**EL PASO COUNTY PLANNING AND
COMMUNITY DEVELOPMENT
DEPARTMENT**

STORMWATER MANAGEMENT PLAN CHECKLIST

Revised: July 2019

SHT. NAME
GRADING AND EROSION CONTROL PLAN

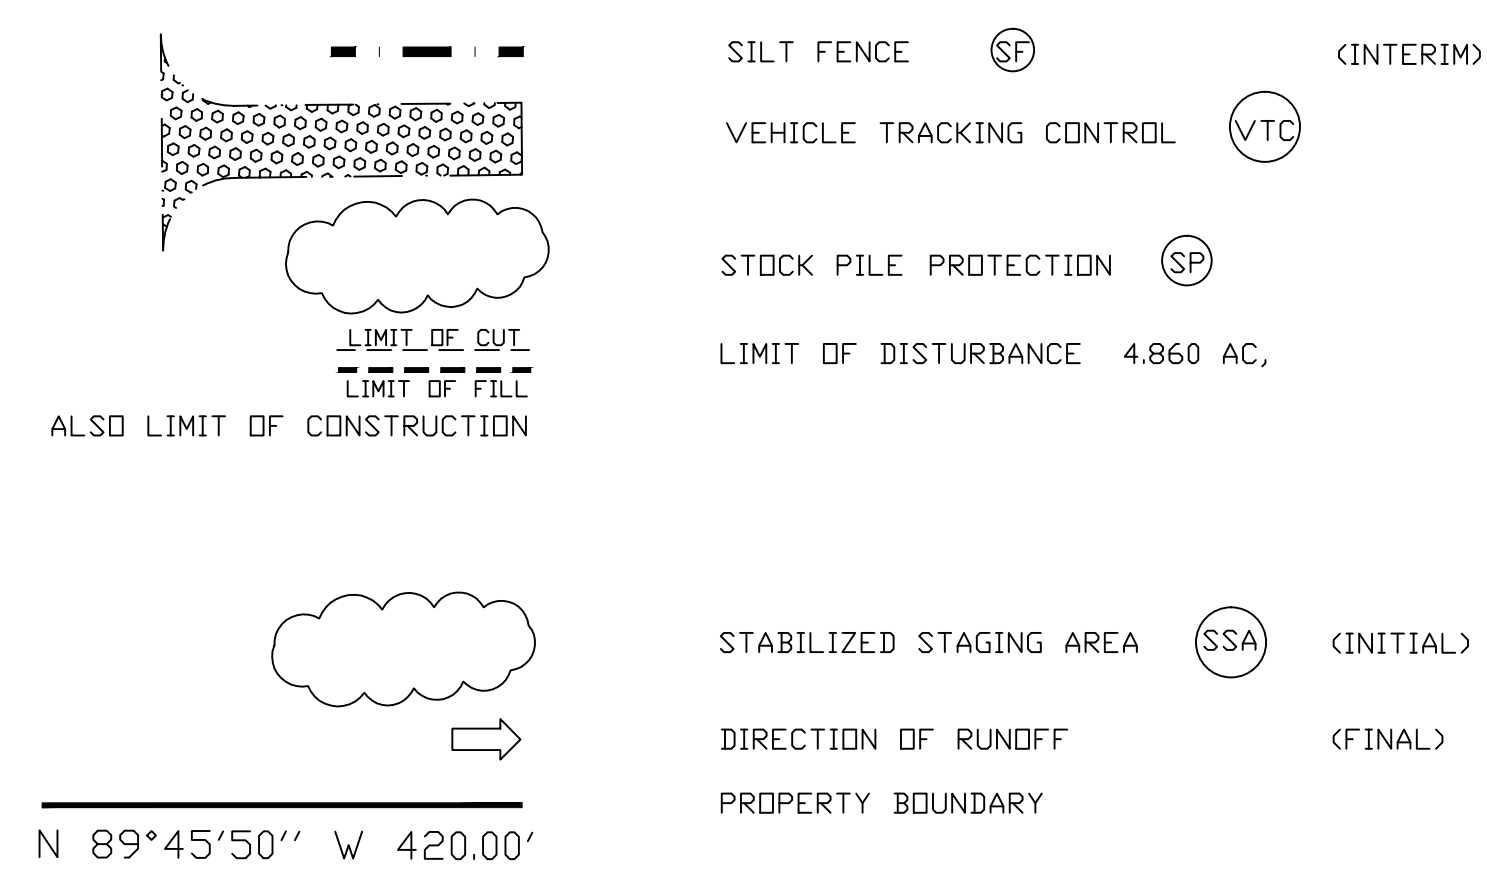
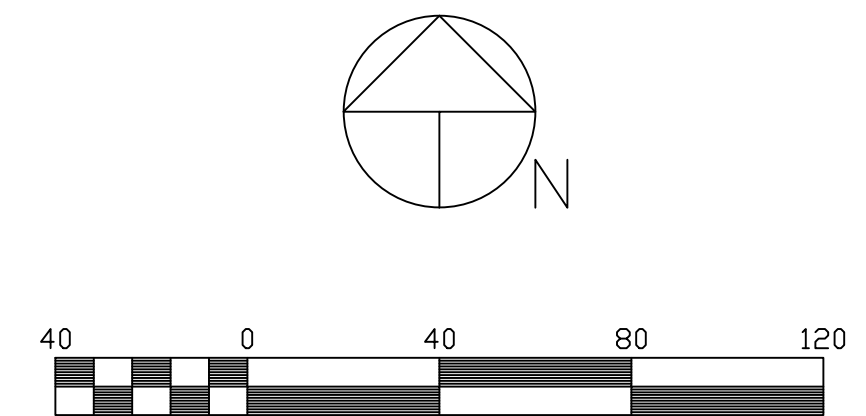
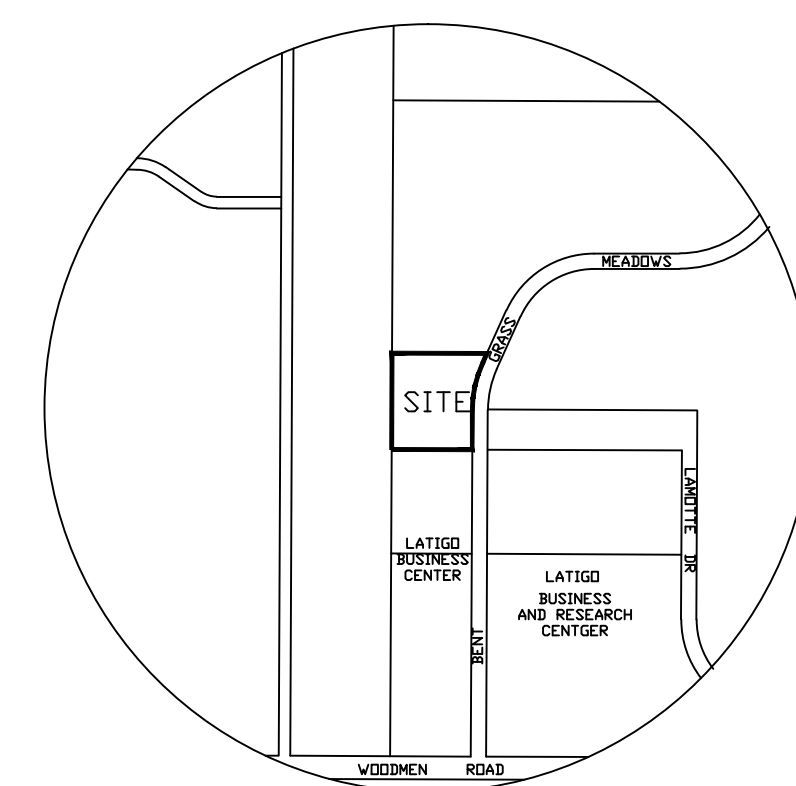
Revised: July 2019		Applicant	PCD
17	SWMP Map to include: see GEC Plan for Items 17a - 17i		
17a	construction site boundaries needs revision/clarification	X	X
17b	flow arrows to depict stormwater flow directions	X	X
17c	all areas of disturbance	X	X
17d	areas of cut and fill needs revision/clarification	X	X
17e	areas used for storage of building materials, soils (stockpiles) or wastes	X	✓
17f	location of any dedicated asphalt / concrete batch plants	X	X
17g	location of all structural control measures	X	X
17h	location of all non-structural control measures	X	X
17i	springs, streams, wetlands and other surface waters, including areas that require maintenance of pre-existing vegetation within 50 feet of a receiving water	X	X
18	Narrative description of all structural control measures to be used. Modifications to EPC standard control measures must meet or exceed County-approved details.	X	X
19	Description of all non-structural control measures to be used including seeding, mulching, protection of existing vegetation, site watering, sod placement, etc.	X	✓
